**CITY OF ALBUQUERQUE  
PLANNING DEPARTMENT  
August 1, 2012  
DRB Comments**

**ITEM # 15**

**PROJECT # 1009355**

**RE: Lot 28, Alvarado Gardens, Unit 1**

AS-101

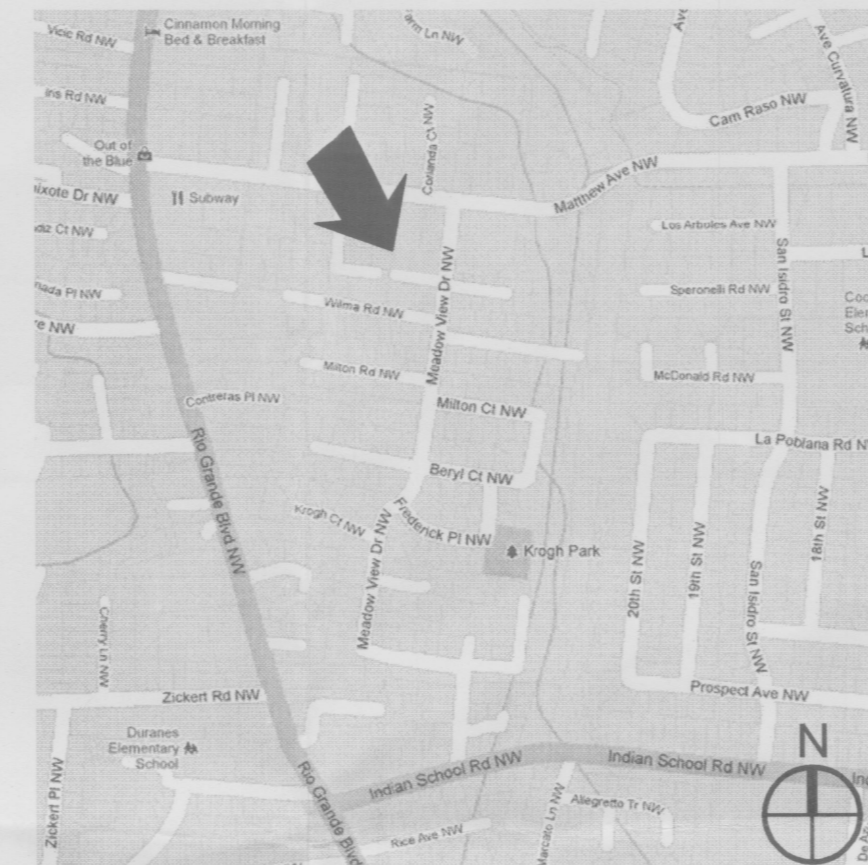
The proposal is for a "portion of" Lot 28 – the creation of this portion prior to the adoption of the current Subdivision Ordinance (1973) must be documented by deed, otherwise all of Lot 28 would need to be included in the plat. Creation of Covina Place as a private road must also be documented, to include access rights.

It appears several subdivision design variances would be required from the maximum number of lots and the maximum length of a stub street, as well as no sidewalk; refer to comments from Transportation Development.
